SUBMISSION OBJECTING TO

Residential flat building with in-fill affordable housing

35-39 Darley Street East, Mona Vale | SSD-113872990

SUBMITTER	John Dorrington	POSITION	Object
CAPACITY	Mona Vale resident	EXHIBITION CLOSES	3 August 2026

3 11AM
SCALE: 1:500@A3

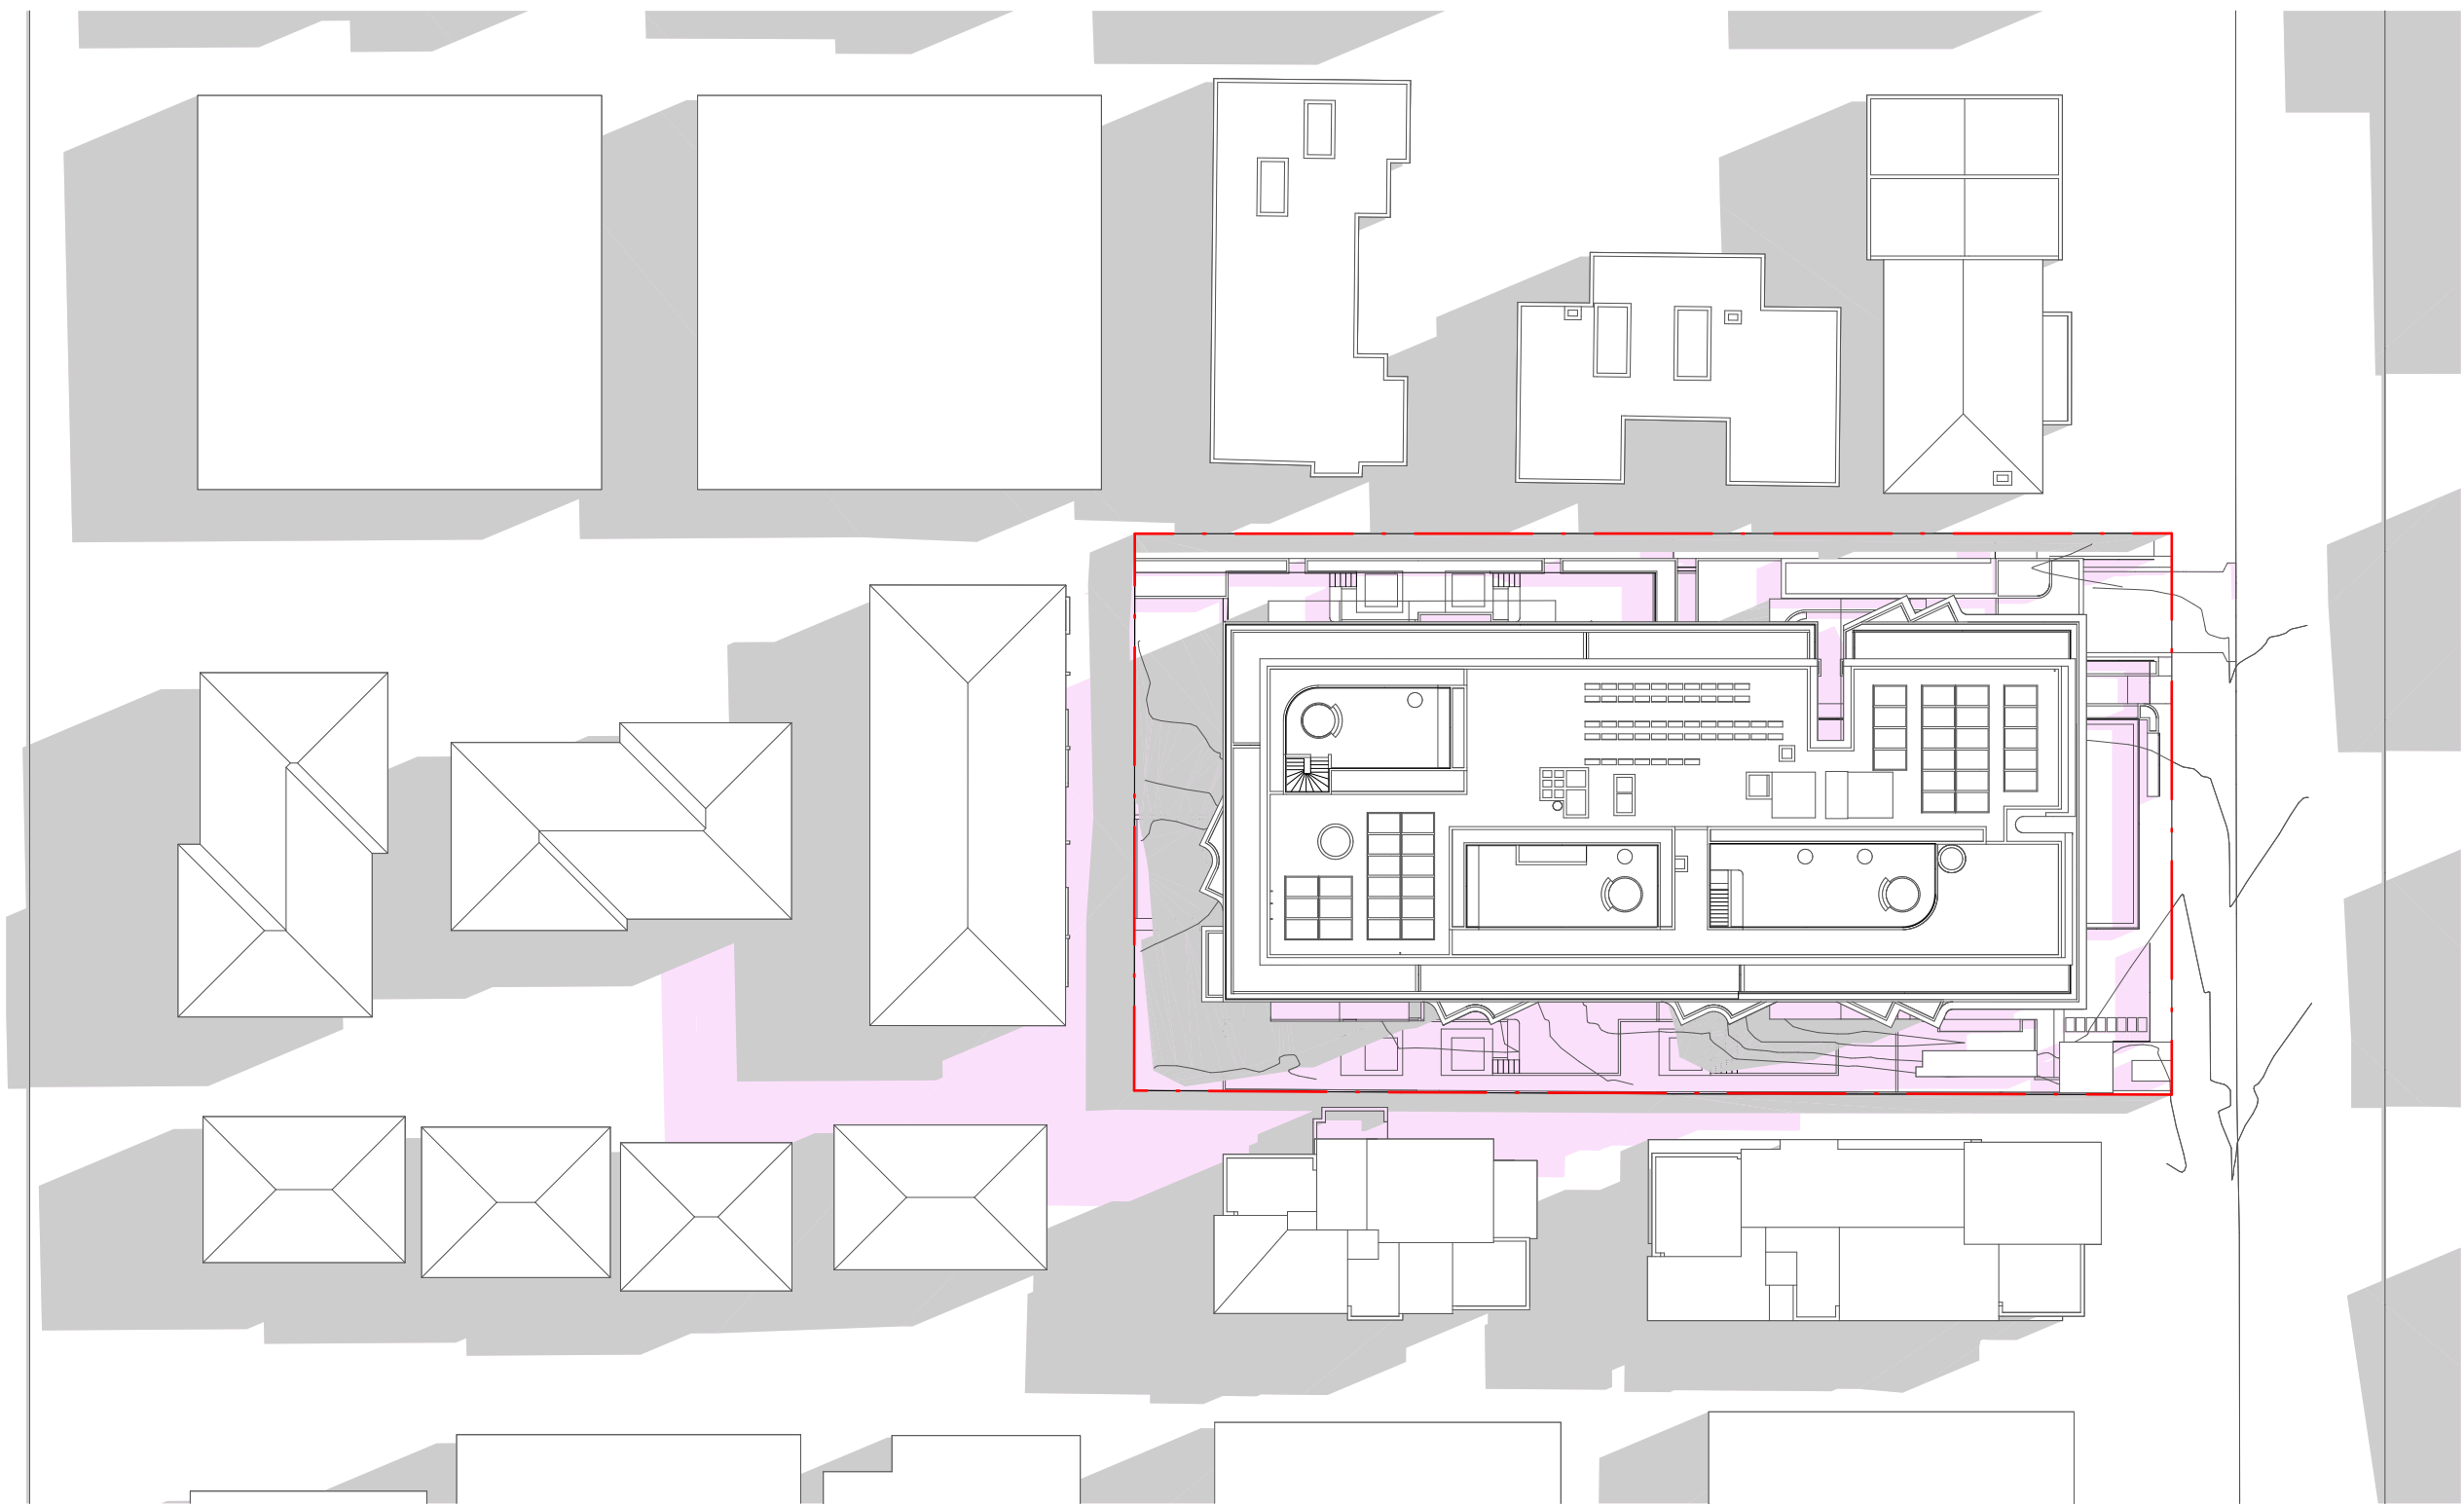
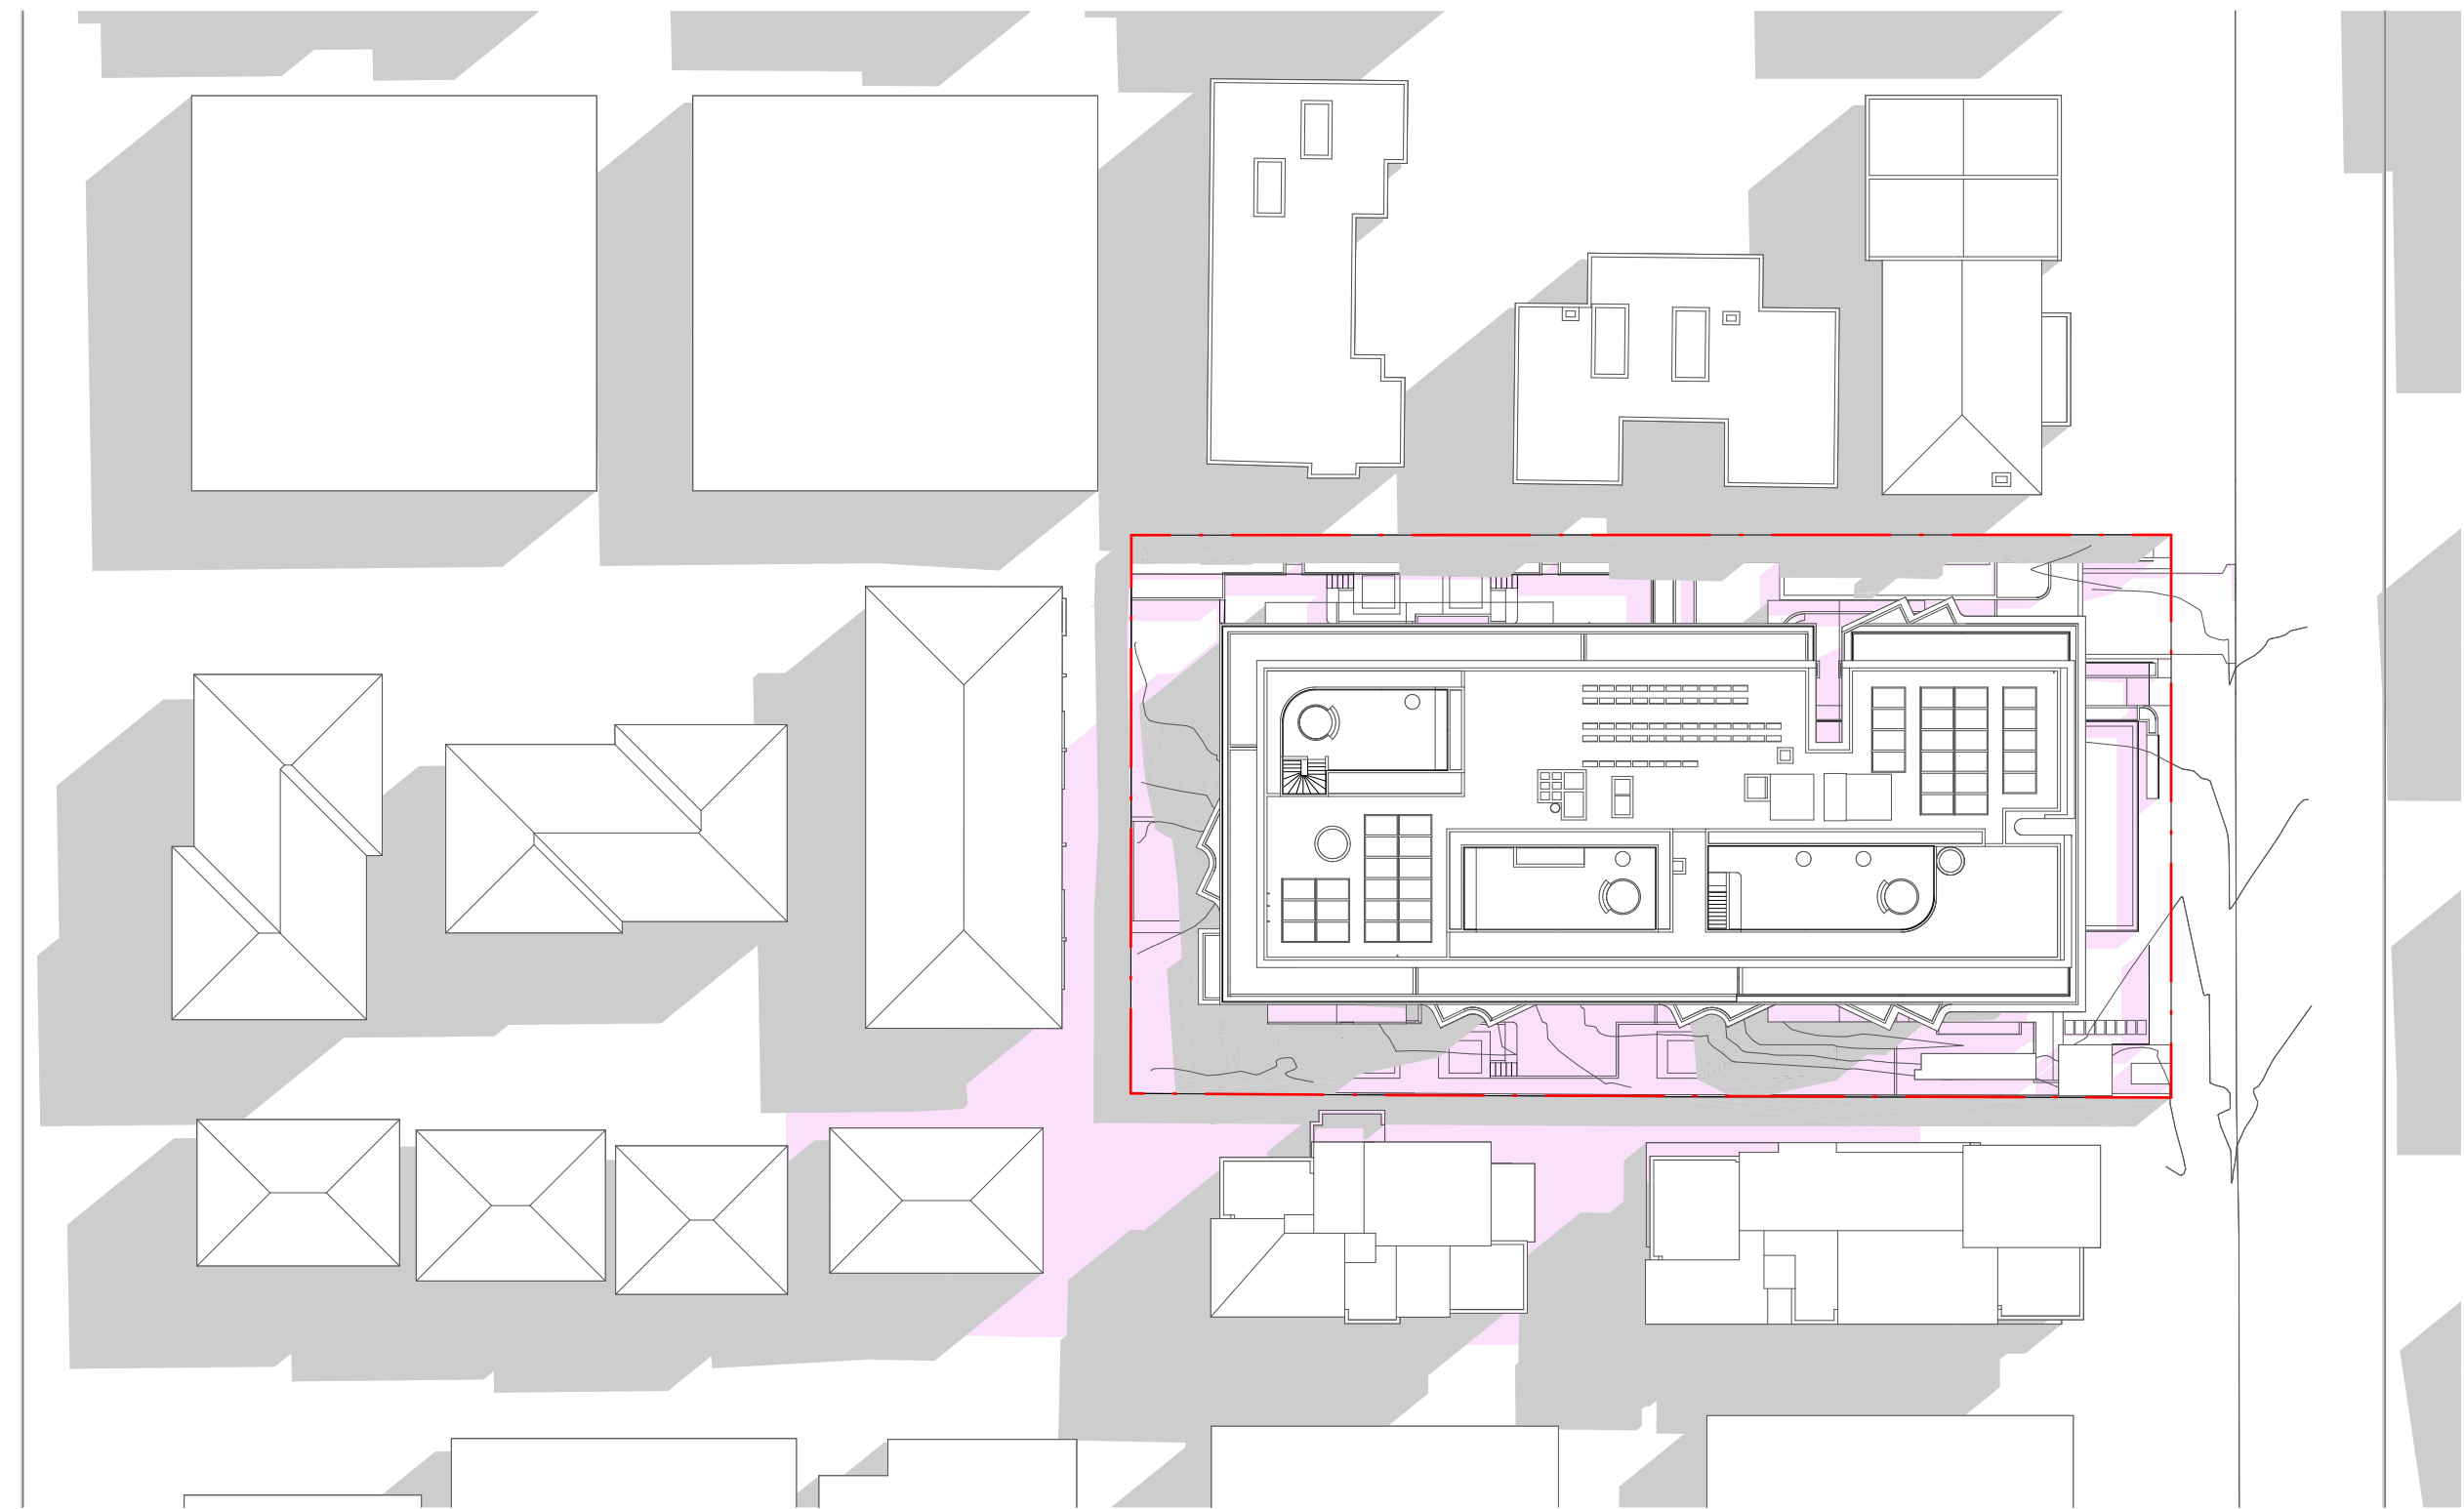
The EIS also concedes that overshadowing is unavoidable and identifies impacts to 28-30 and 32 Golf Avenue, 25-31 and 33 Darley Street East, with additional afternoon shadow extending to 34-36 Golf Avenue. Architectural shadow drawings PLA-DA-4100 and PLA-DA-4101 show new shadow extending across neighbouring land from 9 am through 3 pm on 21 June. The drawings do not support any suggestion of 'no impact'.

Before determination, the Department should require an independent peer review of the shadow model, quantified results for every affected dwelling and private open space, and a comparative analysis demonstrating the reduction achieved by deleting the upper two levels. Additional shadow should not be dismissed merely because a bonus exists.
